From: Sarah Burrow <Sarah.Burrow@arun.gov.uk>
Sent: 07 September 2021 11:59
To: Planning.Responses <Planning.Responses@arun.gov.uk>
Cc: Anita Gardner <Anita.Gardner@arun.gov.uk>
Subject: RE: Planning Consultation on: FG/145/21/DOC

Application No: FG/145/21/DOC

Site Address: Paddock House 44 Ferringham Lane Ferring BN12 5LU

Description of Works: Approval of details reserved by condition imposed under ref FG/115/17/PL relating to Condition Nos 6 - parking spaces, turning facilities & garages, 7 - surface water drainage, 8 - landscaping, 10 - cycle parking, 11 - materials & finishes and 12 - screen walls and/or fences.

Drawing Title
**Surface Water Drainage Layout
and Construction Details**

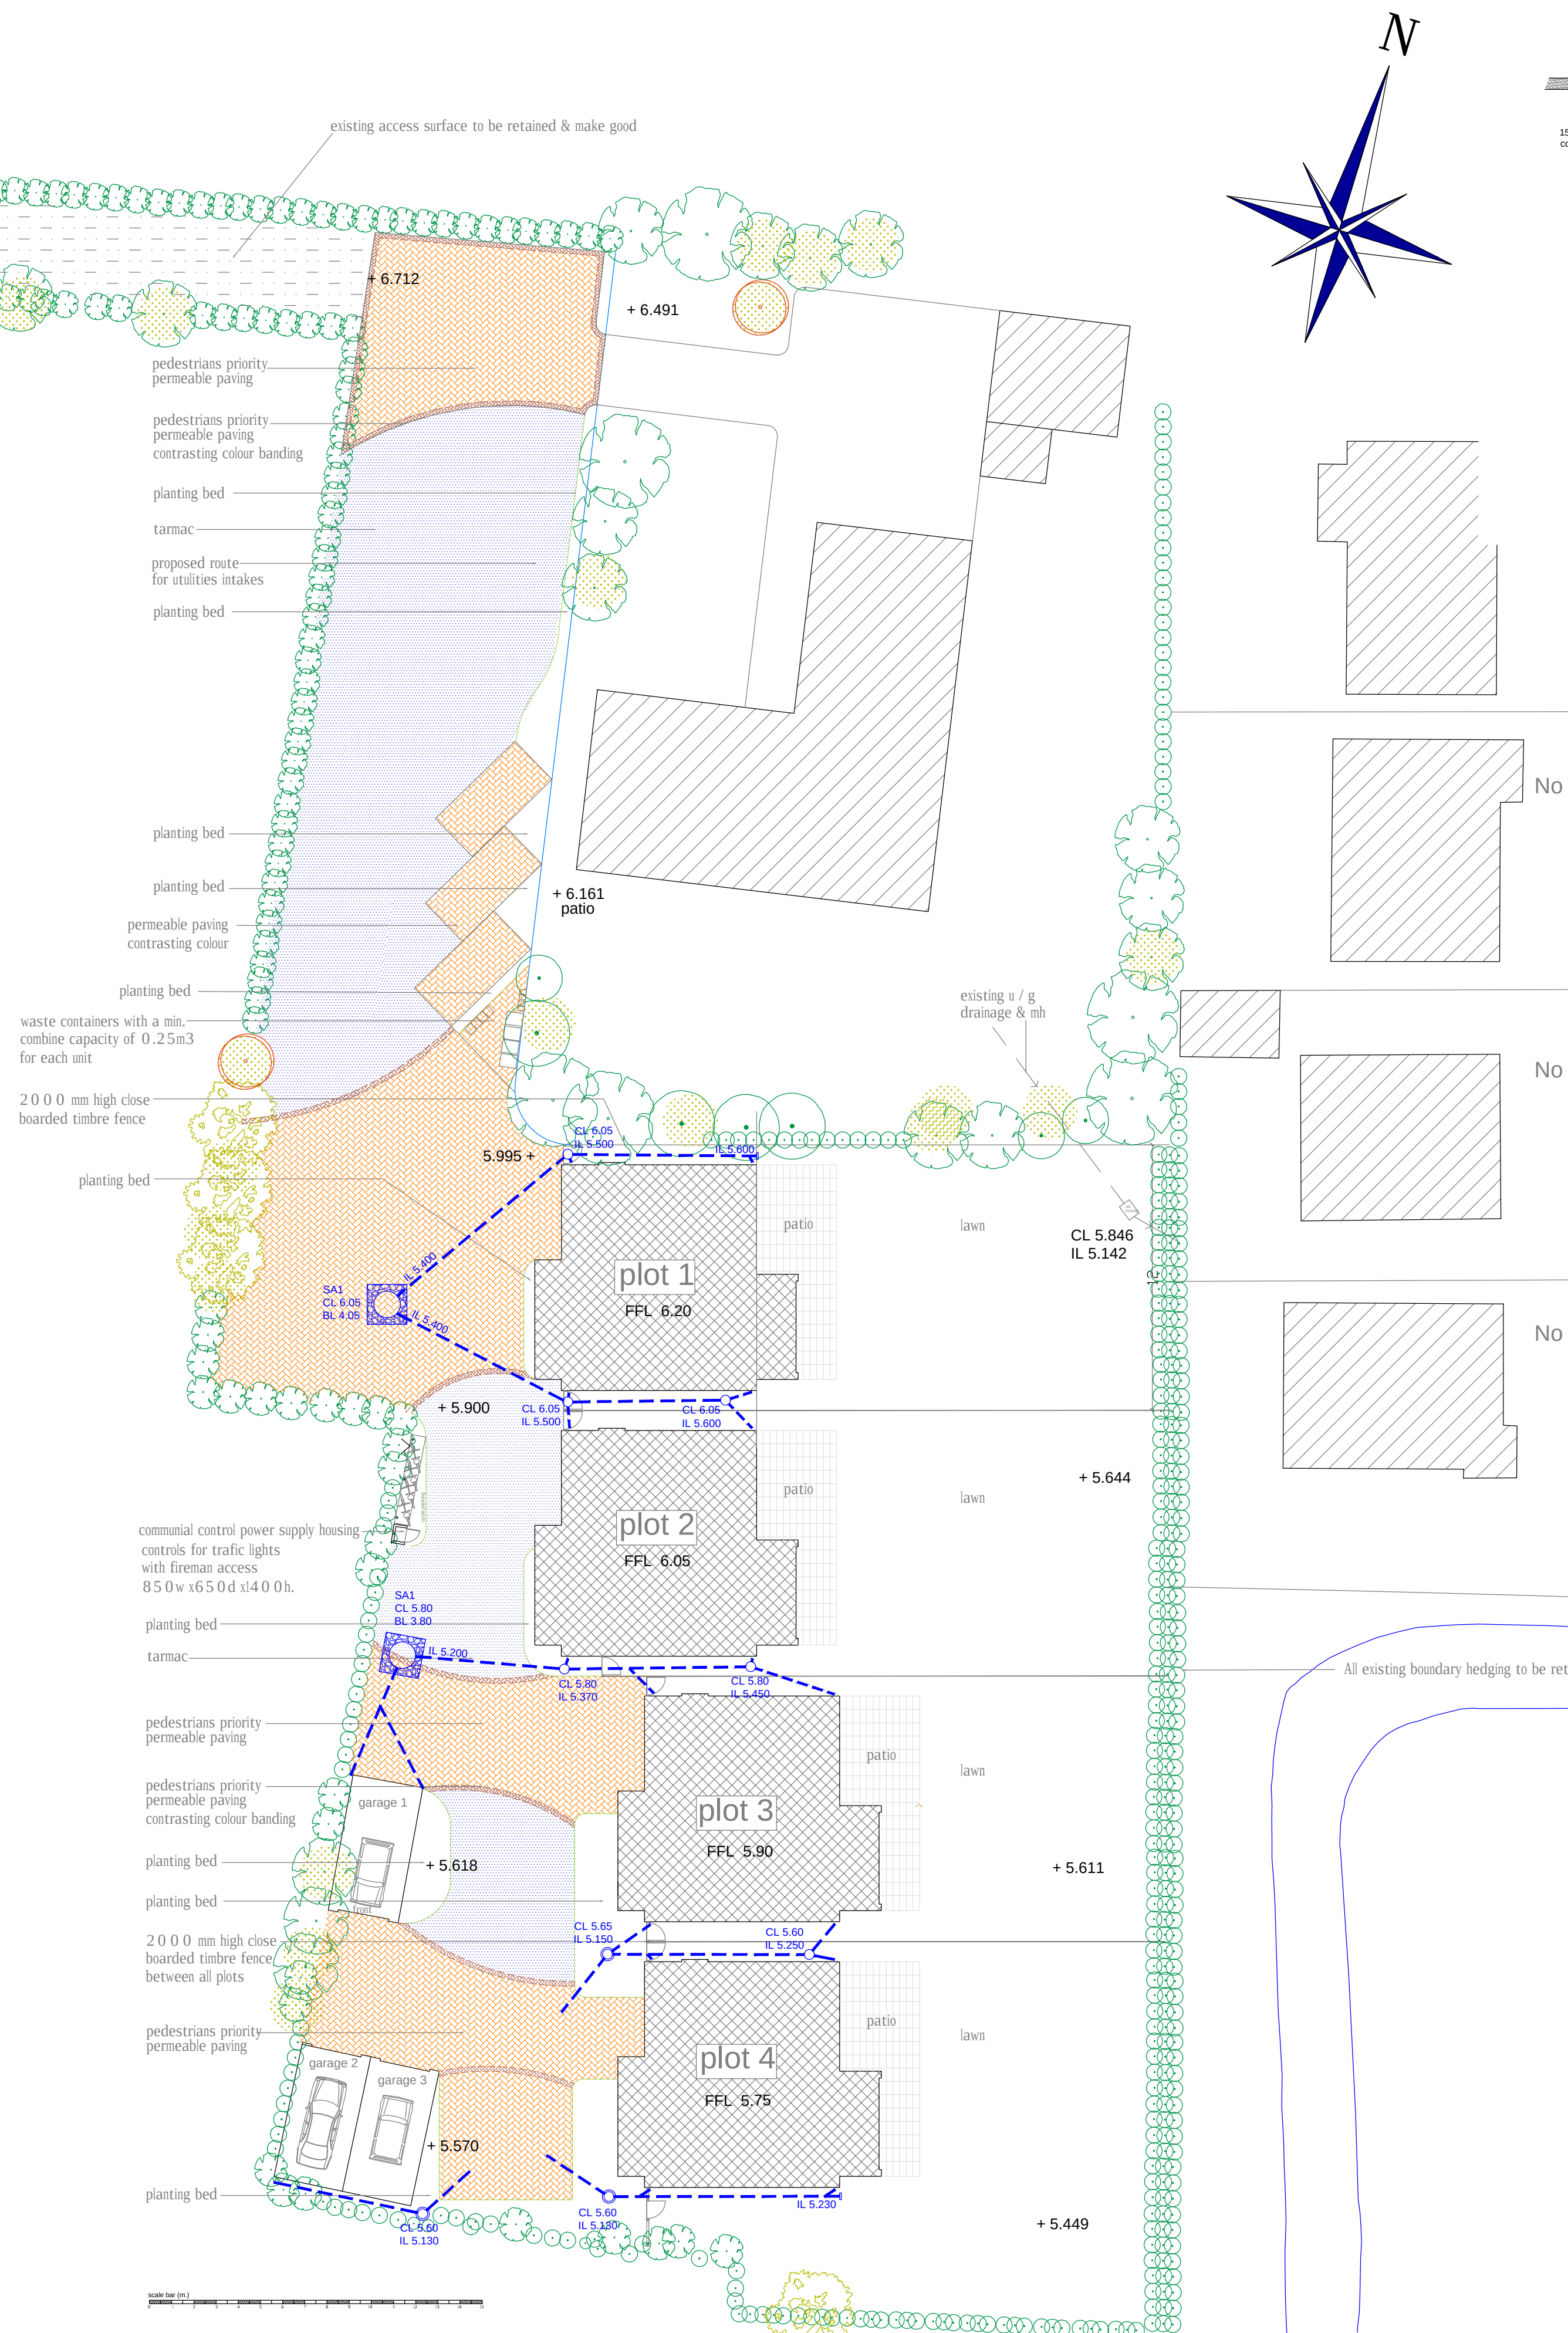
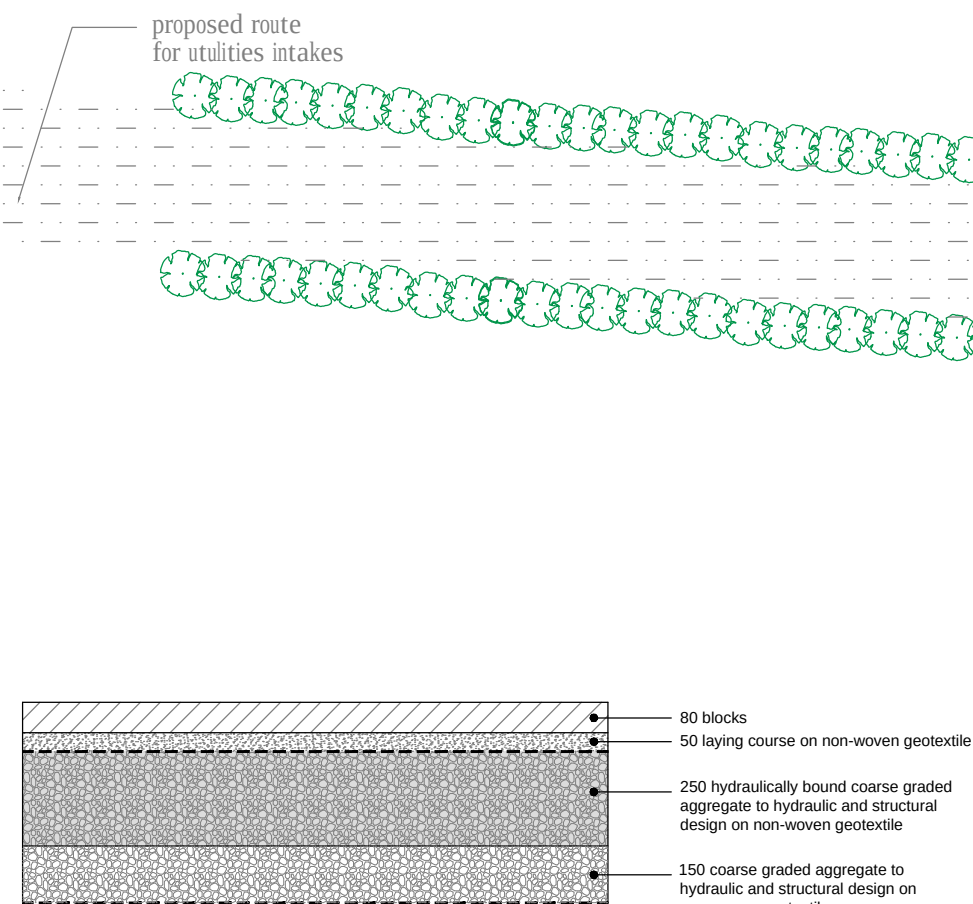
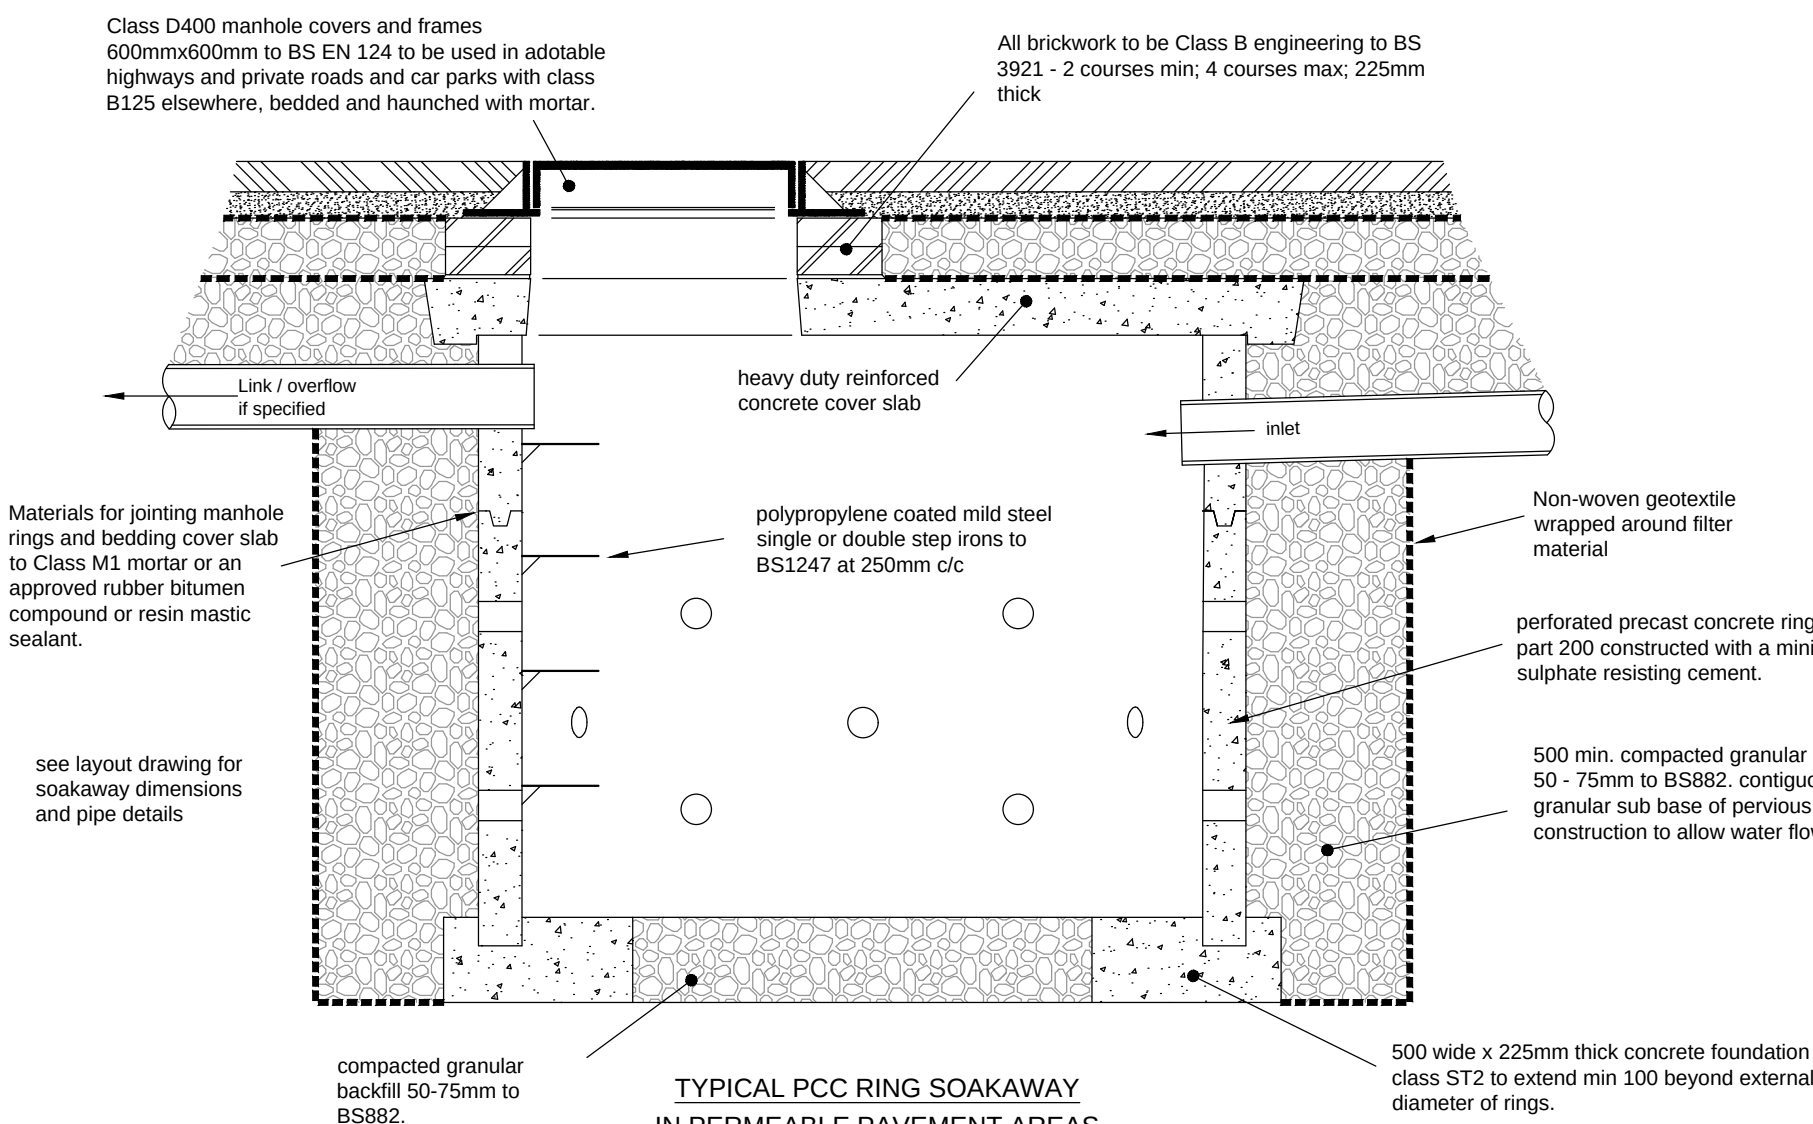
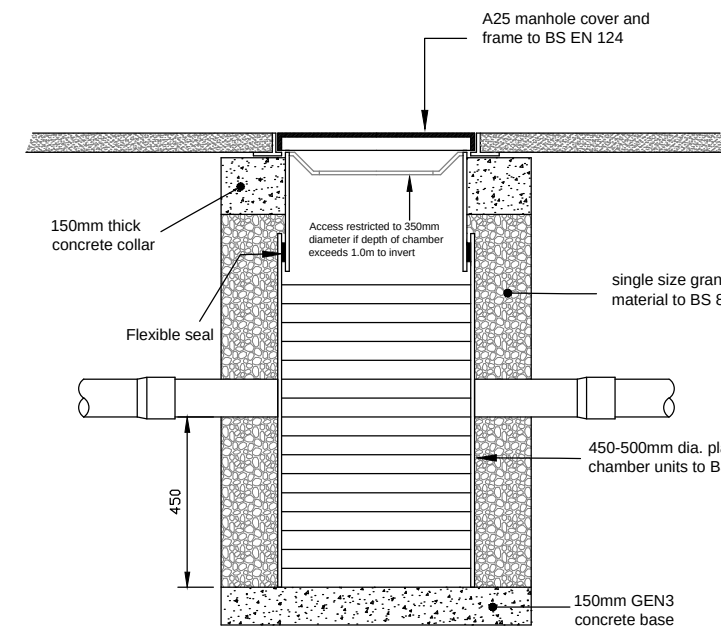
There will certainly be another request for more information following a detailed review of the proposal (once site investigations have been supplied). My initial impression is that the drainage layout will require more detail and we will need construction detail drawings for all components. However, I have not undertaken a review of the calculations or drainage layout at this stage, I will do (and provide a formal consultation response) once I have a better understanding of the conditions on site.
